SSD 6011 - Mixed use residential development within the South West Plot

Submission by:

Vaughn & Matilda de Vocht

23 July 2013

## Winter Solstice (21<sup>st</sup> June)

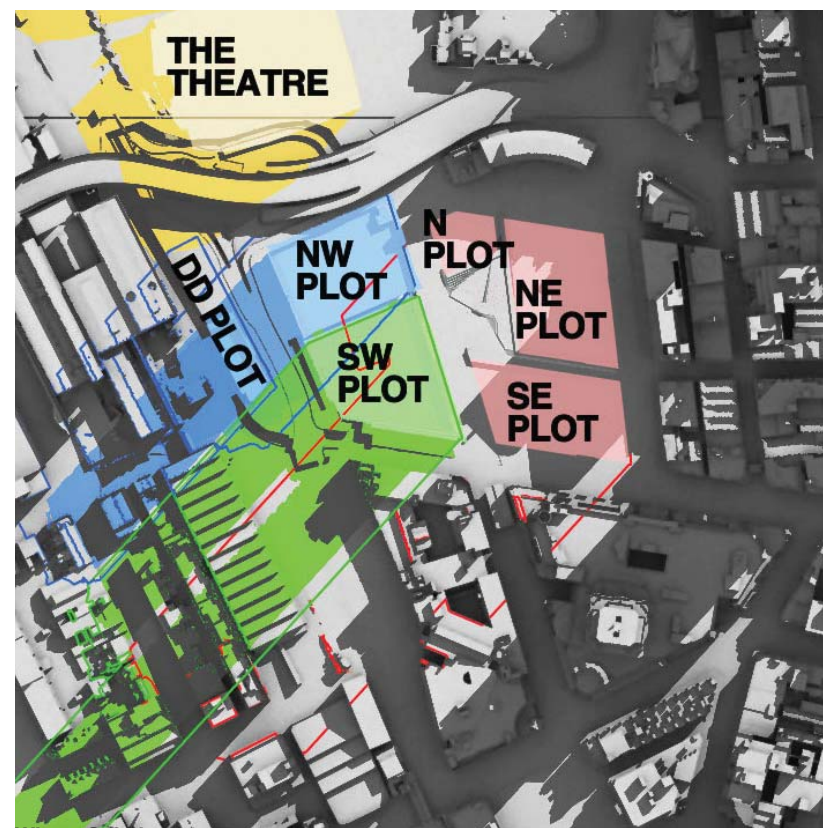
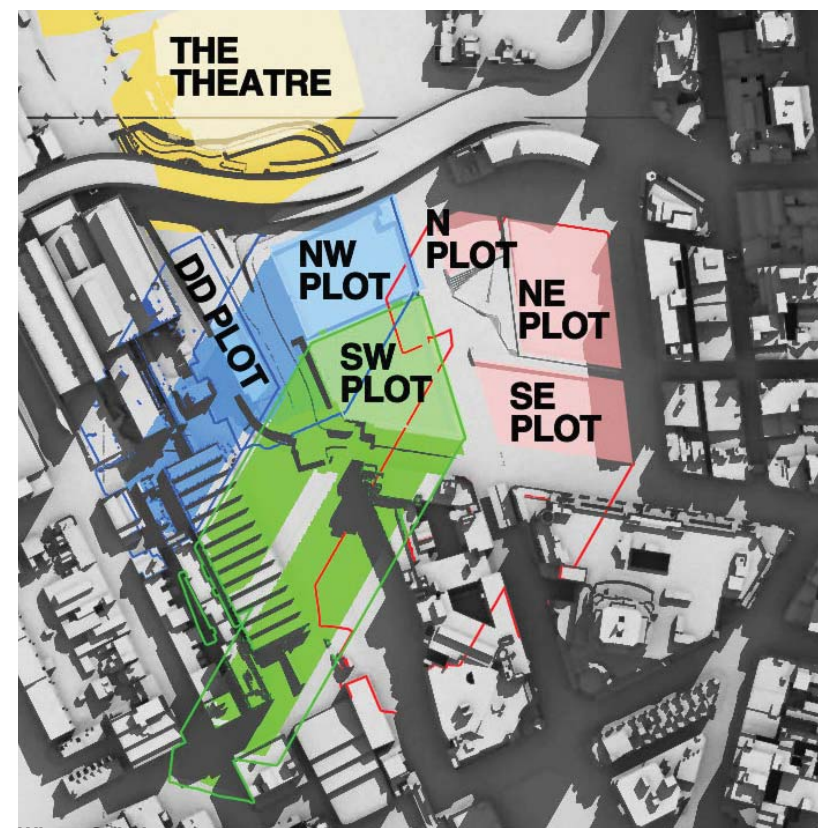
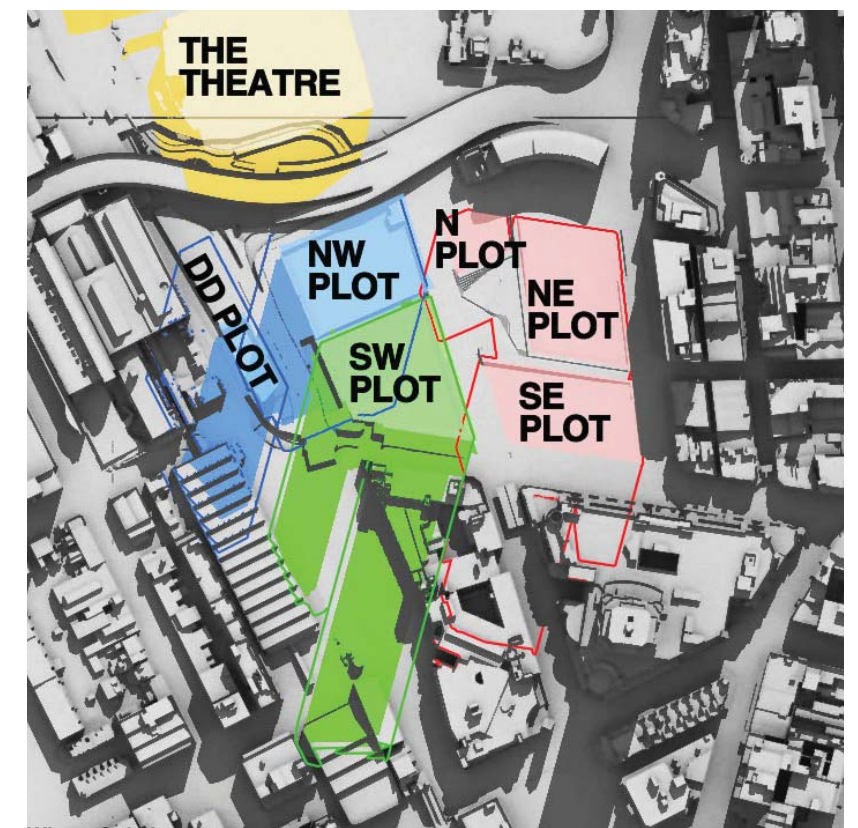
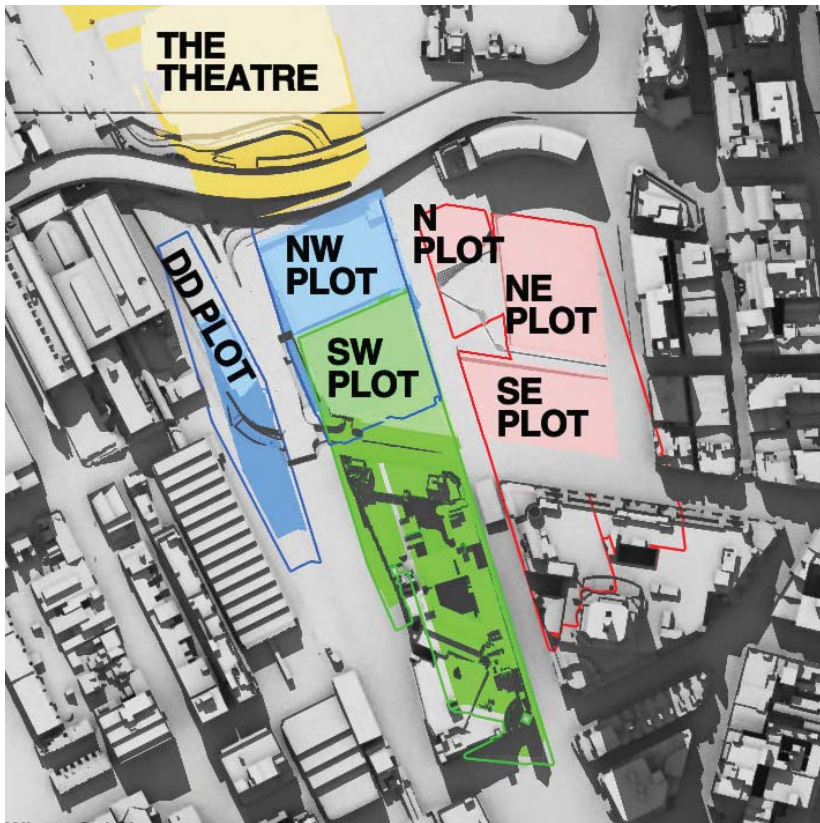
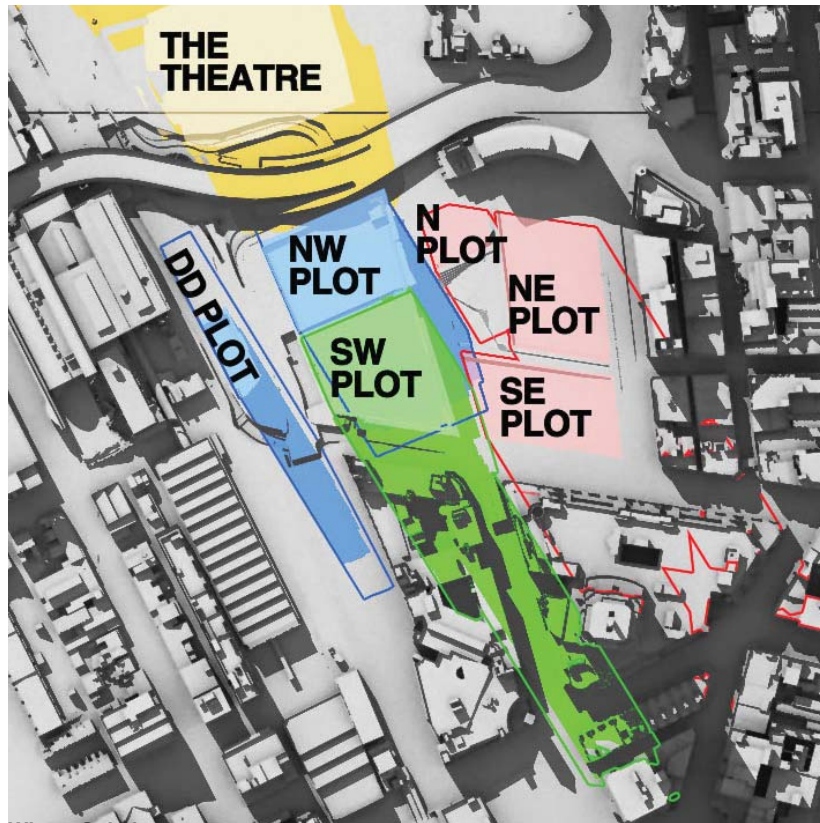
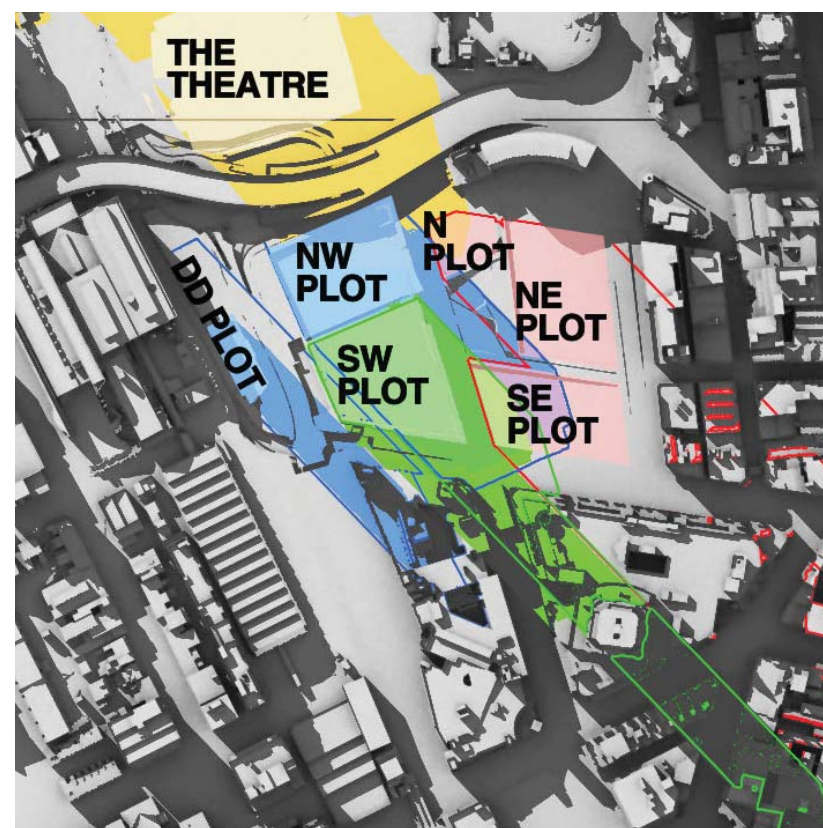
At 9am, 10am and 11am the west façade is totally in shadow due to other parts of The Peak building itself.

At 12pm there is still substantial existing shadowing on the west façade caused by the irregular shape of the west facade.

At 1pm the existing shadowing has been substantially removed, but not totally removed.

It can be concluded that some single aspect apartments on the west façade and some south-west dual aspect corner apartments currently receive less than 2 hours direct sunlight to habitable rooms and 50% of the private open space between 9am and 3pm on 21 June.

By 2pm the existing shadowing has been totally removed, but that is too late to achieve two hours of direct sunlight before 3pm.

At 9am, 10am and 11am the west façade is totally in shadow due to other parts of The Peak building itself.

At 12pm there is still substantial existing shadowing on the west façade caused by the irregular shape of the west facade.

At 1pm the existing shadowing has been substantially, although not entirely, removed. However, overshadowing of lower levels of the west façade by the concept proposal parameter plan shadows for the N,NE and SE plots has already started.

By 2pm the existing shadowing has been totally removed. However, overshadowing of the west façade by the SSDA4 and SSDA5 buildings has appeared and risen further up the west façade than the concept proposal parameter plan shadows for the N,NE and SE plots, which is still present.

At 3pm, the proponent states correctly that 45-45% of the western façade is overshadowed by the SSDA4 and SSDA5 buildings.

It can be concluded that, as a result of combination of the proposed development with existing shadowing of the west façade, some single aspect apartments on the west façade and the south-west dual aspect corner apartments which currently receive less than 2 hours direct sunlight to habitable rooms and 50% of the private open space between 9am and 3pm on 21 June will suffer additional overshadowing. It is beyond our skills to count the number of such apartments. We note that the proponent has made no attempt to do so.

Rather than counting the number of units which will not meet the DCP guidelines, the proponent attempts to trade-off direct sunlight at 4pm for lack of direct sunlight during the period 9am to 3pm. There is no provision in the DCP guidelines for such a trade-off.
